Outer Dowsing Offshore Wind Farm

Appendix F4 to the Natural England Deadline 4a Submission

Natural England's Advice on Offshore and Intertidal Ornithology Apportioning [REP4-033] and the Red-Throated Diver Feature of the Greater Wash SPA within the Report to Inform the Appropriate Assessment [REP4-030]

26th February 2025

Environmental Statement  
 Displacement Buffers from the ORCPs  
 Figure 12.2

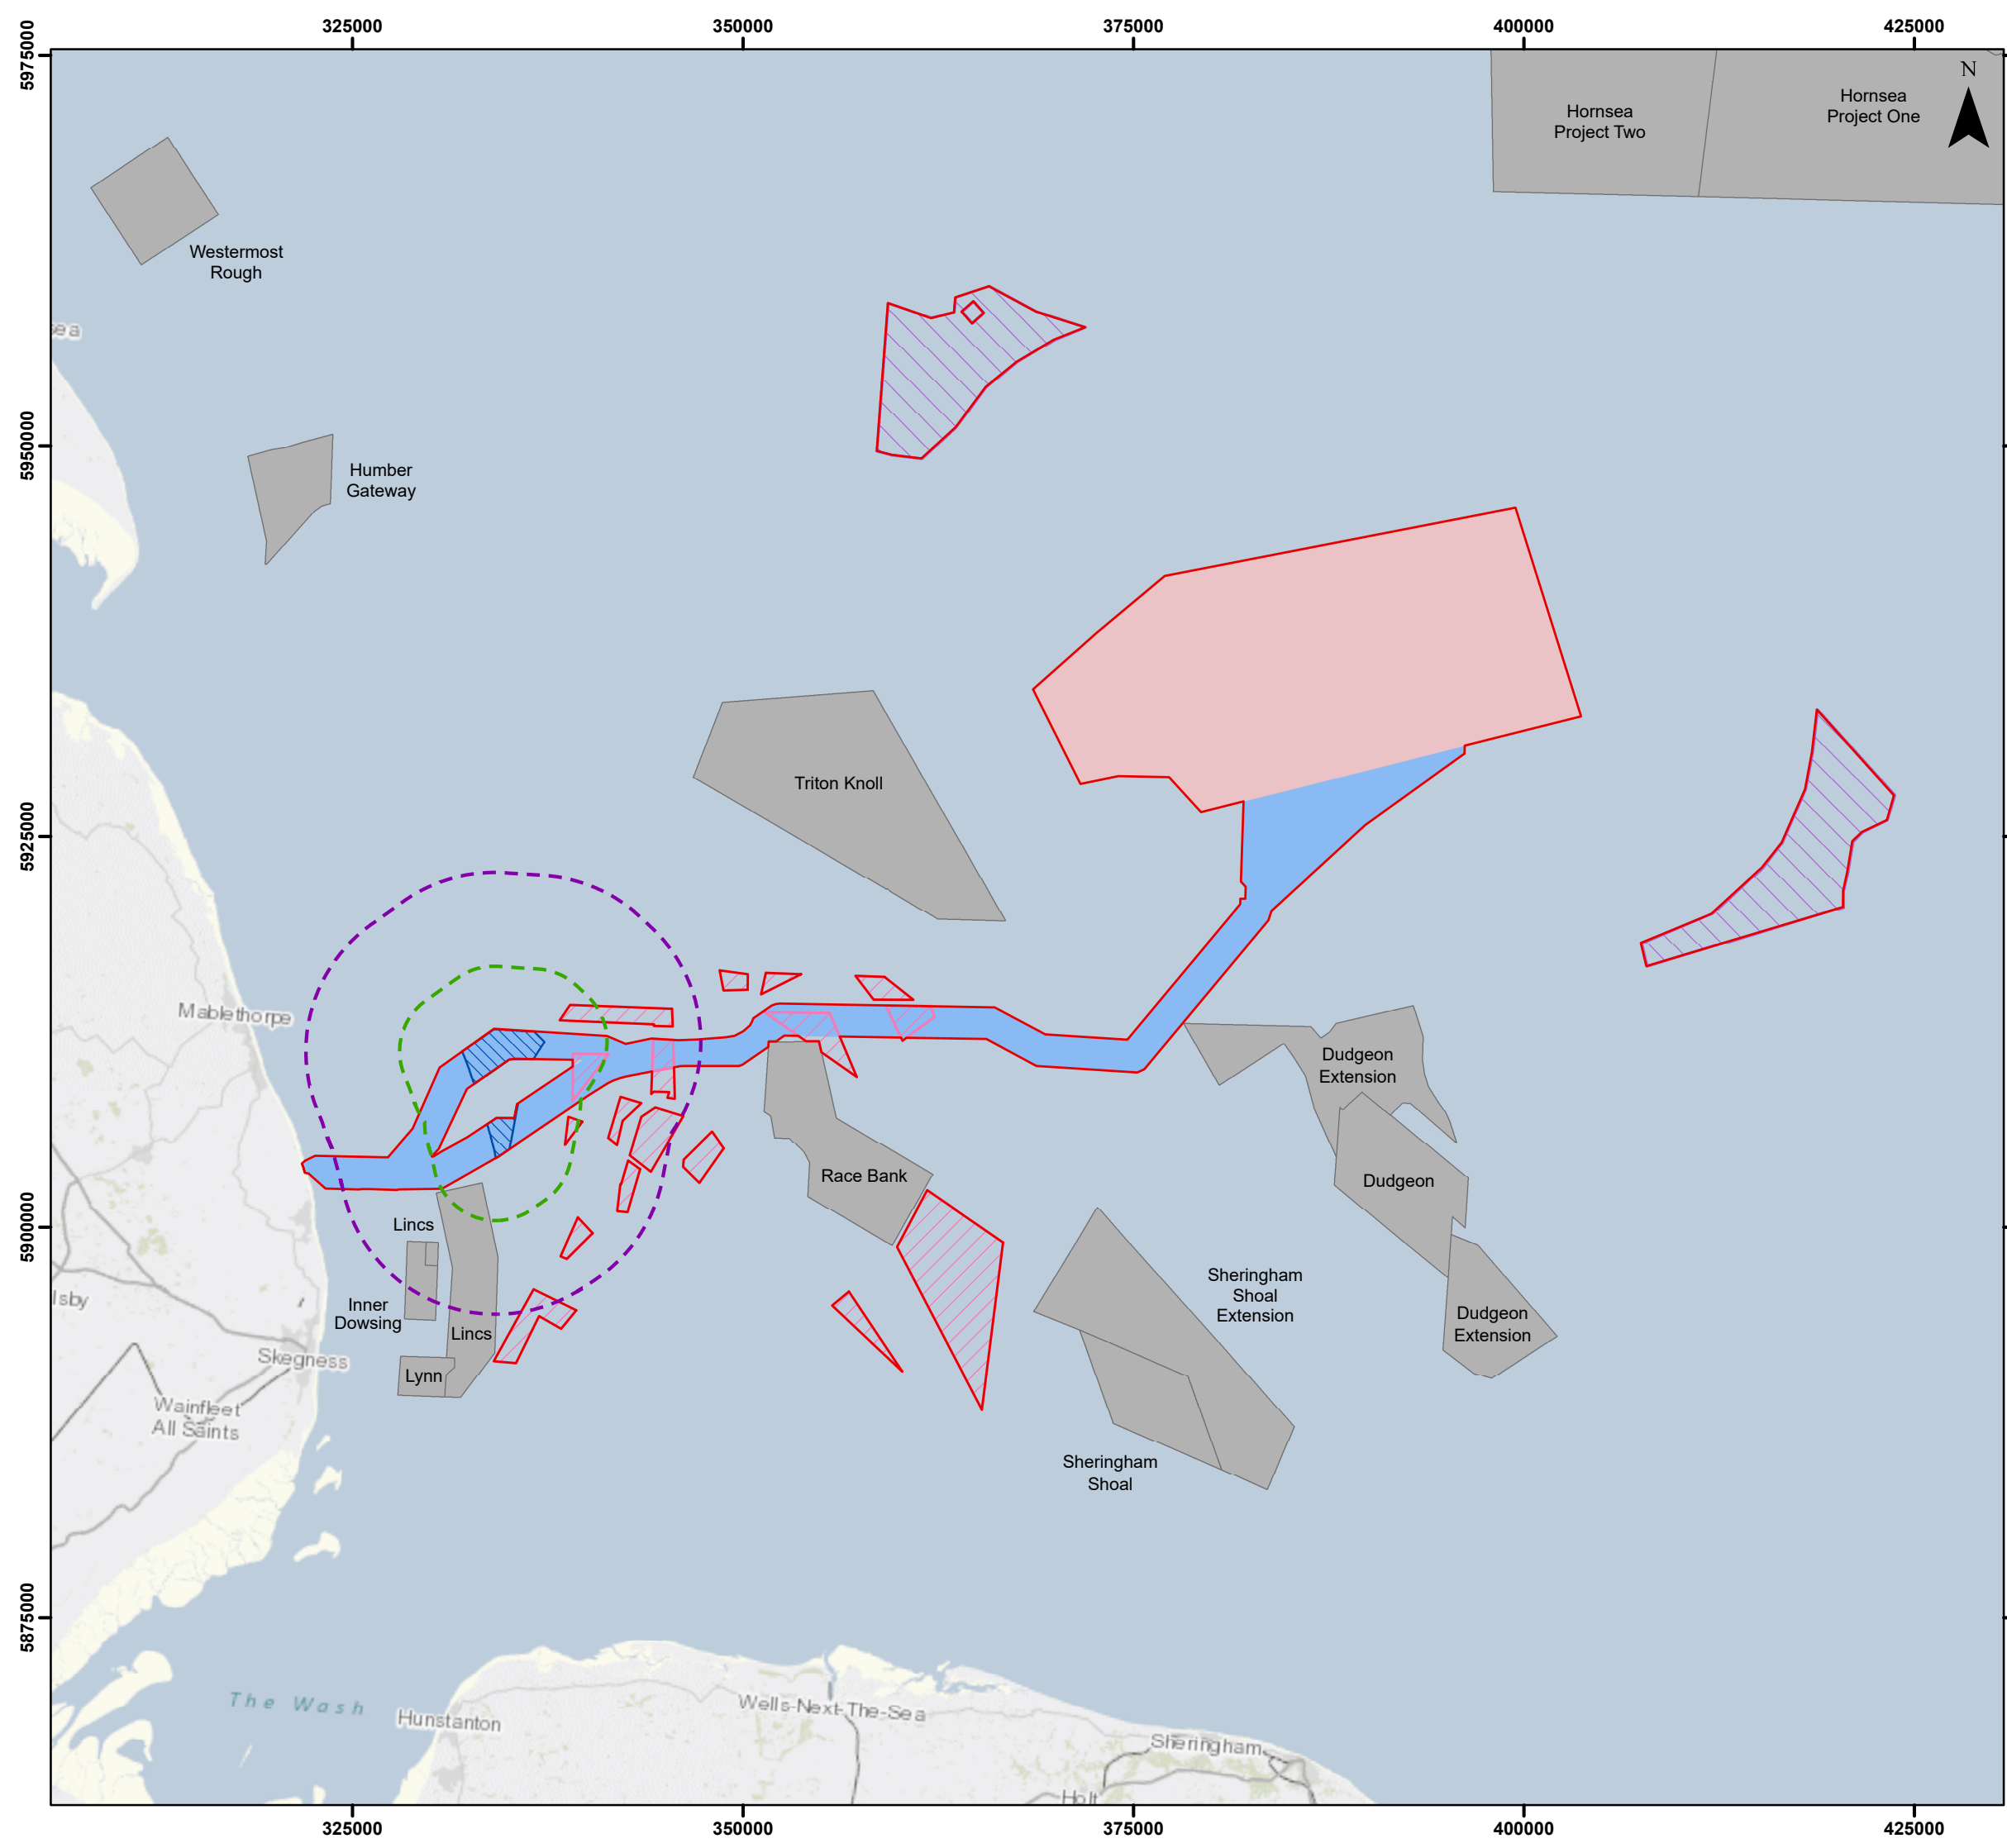
Within the updated RIAA [REP4-030] submitted at Deadline 4, the Applicant has provided an updated assessment for the red-throated diver feature of the Greater Wash Special Protection Area (SPA) (paragraphs 746 to 768), specifically with regards to potential displacement due to the presence of the Offshore Reactive Compensation Platform(s) (ORCP). This included

Figure 9.8 which demonstrates that the ORCP area and a 5km buffer around it sits wholly within the 10km buffers of existing offshore wind farms (namely Lincs, Lynn and Inner Dowsing), and that the ORCP area and a 3km buffer sits within 8km of these Offshore Wind Farms (OWFs).

Whilst acknowledging that the distance of displacement effect from structures such as the ORCPs is unknown, a risk-based judgement can be made on a range of potential displacement distances between 2km (as currently accepted by Natural England and others for estimating displacement from static or slow moving vessels) to 5km (half the distance used for estimating the displacement from a windfarm array). On balance, we consider that although there is the possibility that additional displacement effects in such areas could arise from the presence of the ORCP(s), due to the likely displacement effect being exerted by the existing windfarms, this is unlikely to represent a substantial additional pressure on the distribution of divers within the SPA. For avoidance of doubt, this may not be Natural England's advice on other such structures within diver SPAs but out with the displacement halo of OWFs, or indeed structures located at a greater distance from OWF.

As well as arising from the presence of the ORCP, residual impacts to red-throated diver are likely to occur as a result of cable-laying vessels during the construction of the Export Cable Corridor (ECC), and vessels transiting through the SPA to both the ORCPs and the array during the Operation and Maintenance phase. These matters need to be considered in tandem rather than in isolation. Natural England therefore welcomes the proposed commitment by the Applicant as set out within their change notification (21.22 -The Applicant's Change Notification dated 20 February 2025) by way of a deemed marine licence condition to implement a seasonal restriction on construction activities within the Greater Wash SPA with no construction associated with the offshore export cable and ORCP installation occurring within the SPA during the sensitive period of 1st November to 31st March (inclusive), thus removing the impacts from construction of the ECC and further mitigating the overall impacts from vessel traffic. However, it is not clear whether this restriction will extend to both the SPA and a 2km buffer, as is used by the Applicant for the best practice vessel management protocol. Natural England considers that the spatial extent of the seasonal restriction should include a 2km buffer around the SPA.

On the basis of the above, should a condition be included within the deemed marine licence that refers to both the SPA and a 2km buffer, Natural England is satisfied that the Project alone would not contribute to in-combination impacts to the red-throated diver feature of the Greater Wash SPA.
